HERTFORDSHIRE ECOLOGY

Reference: 6/2022/1943/FULL

Address: Land between 48 & 50 The Ridgeway Cuffley EN6 4BA

Application: Erection of a new dwelling with associated landscaping works

Title Root Protection Areas - Sheet 2

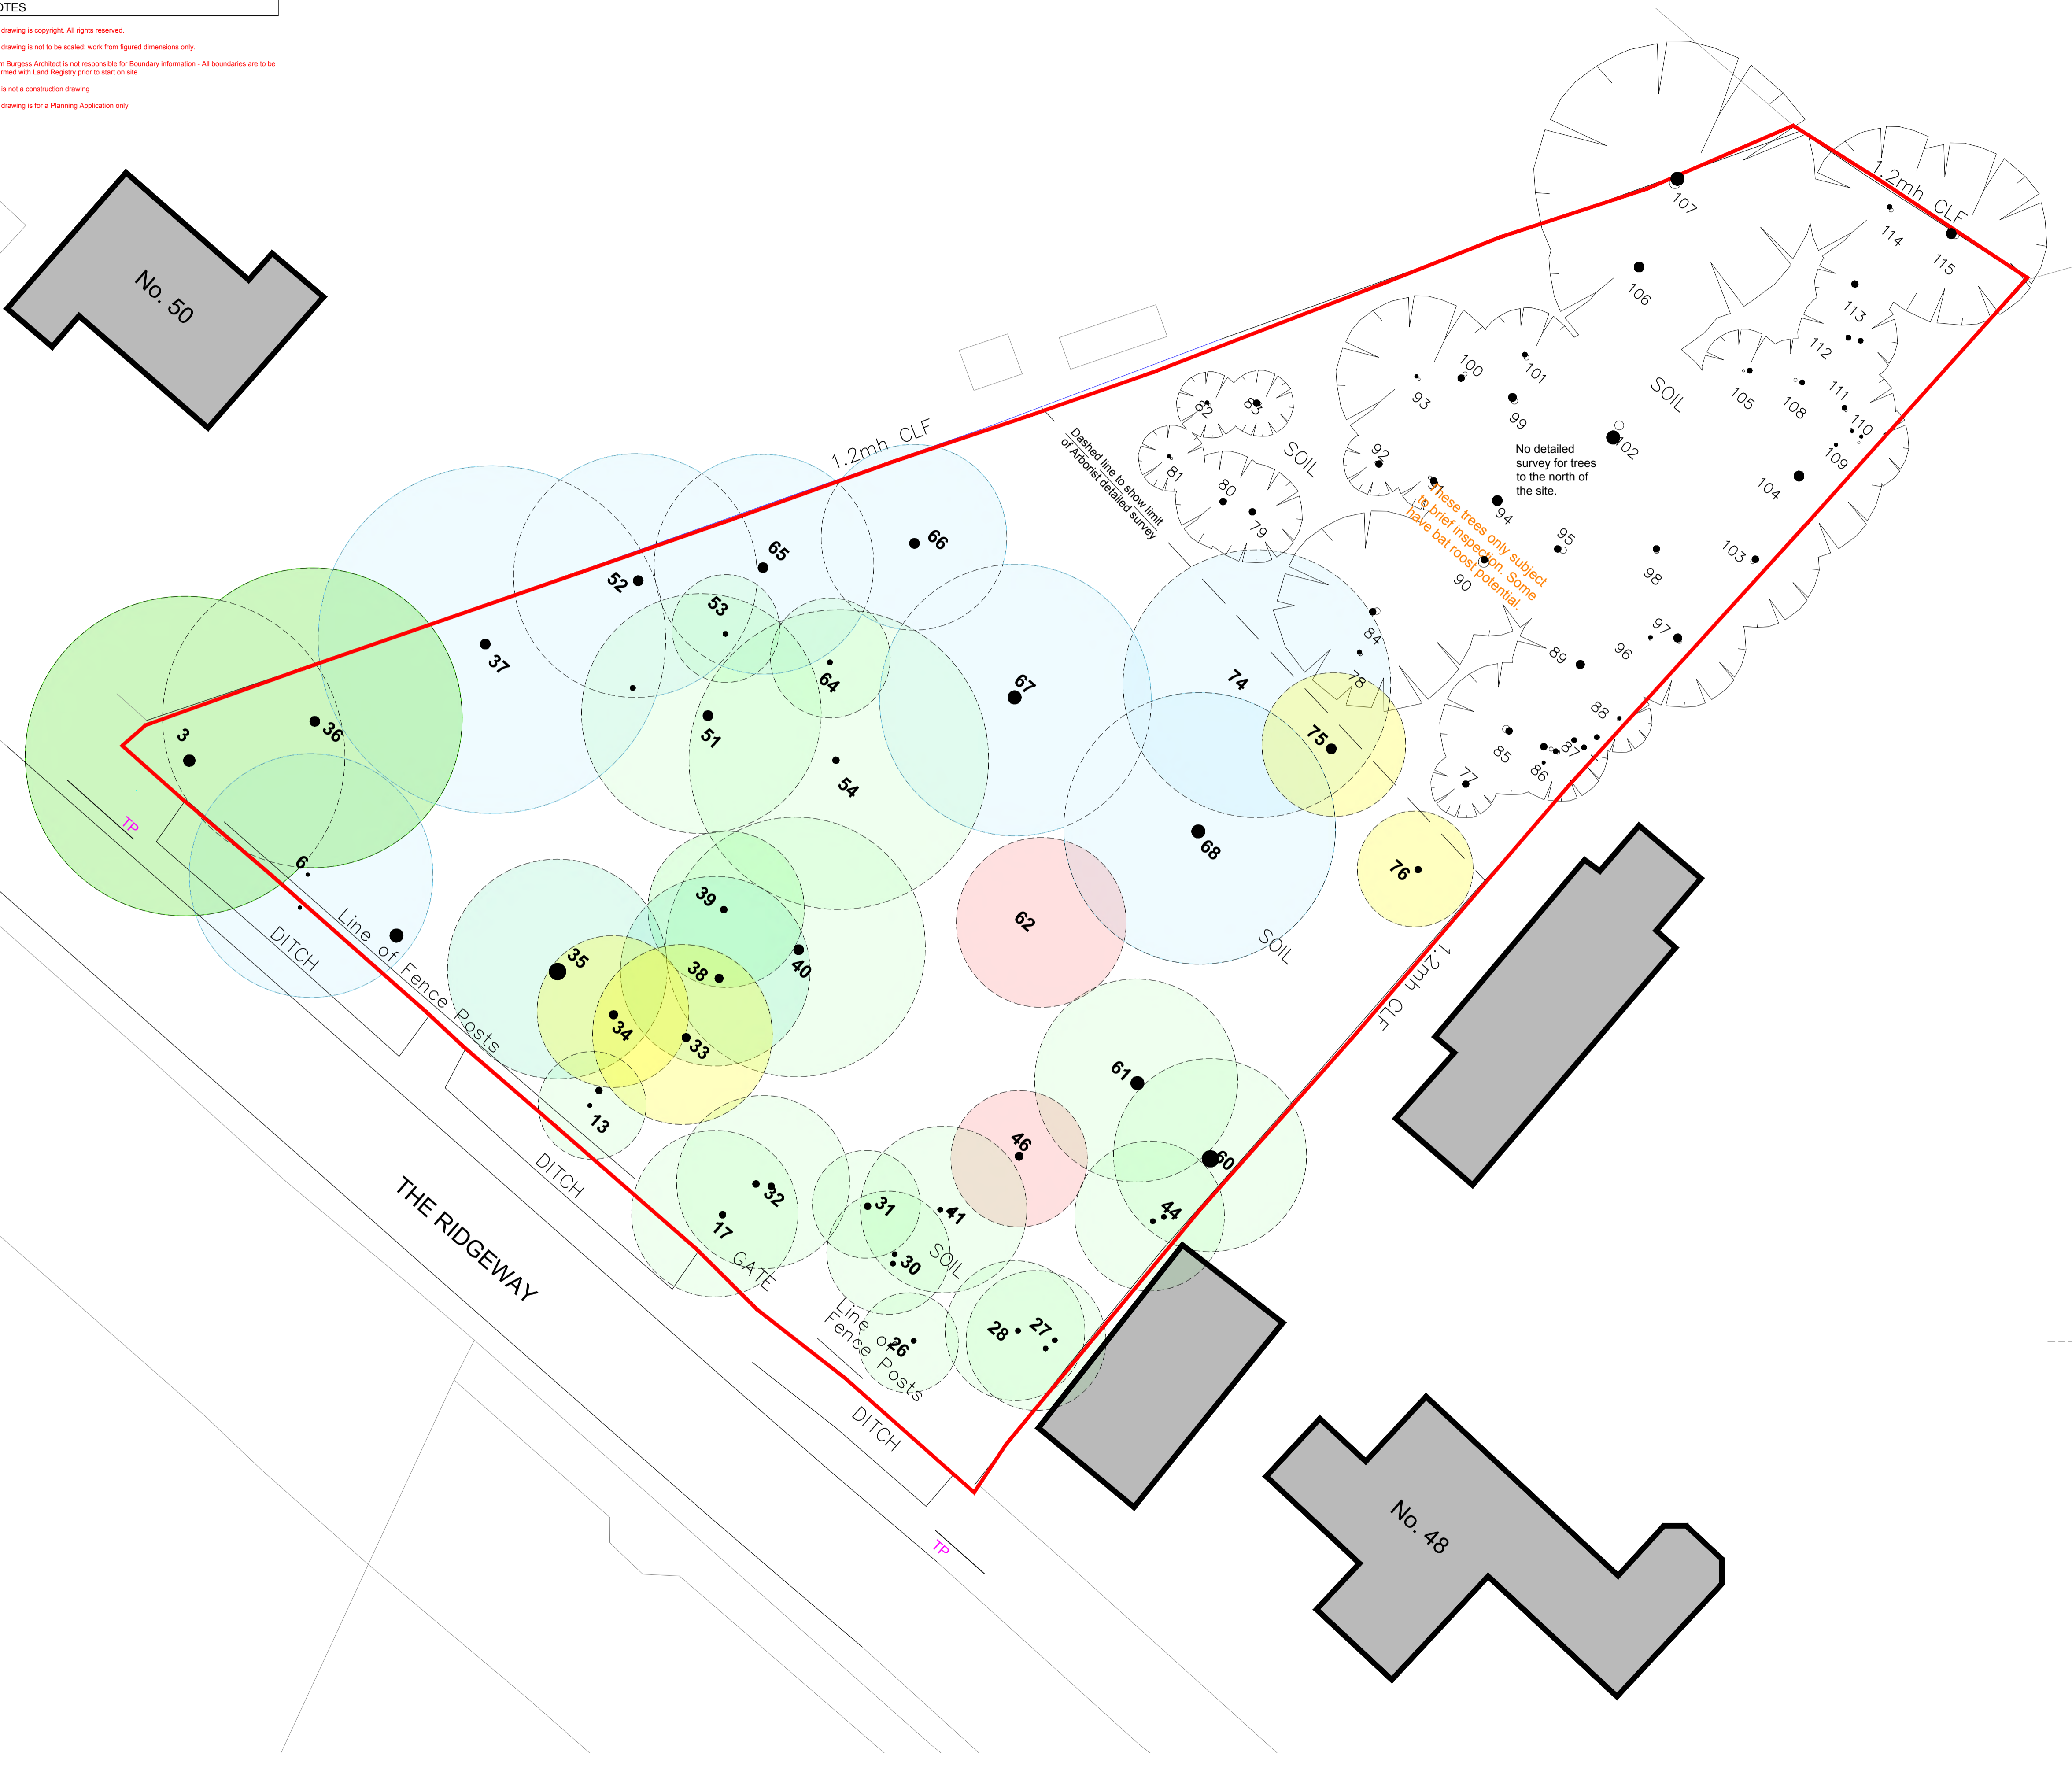
The development will directly result in the loss of two semi mature trees T62 hornbeam, T46 hornbeam. However, the impact of the development should be considered according to its impact on all of the elements of the woodland including its soils and ground cover.
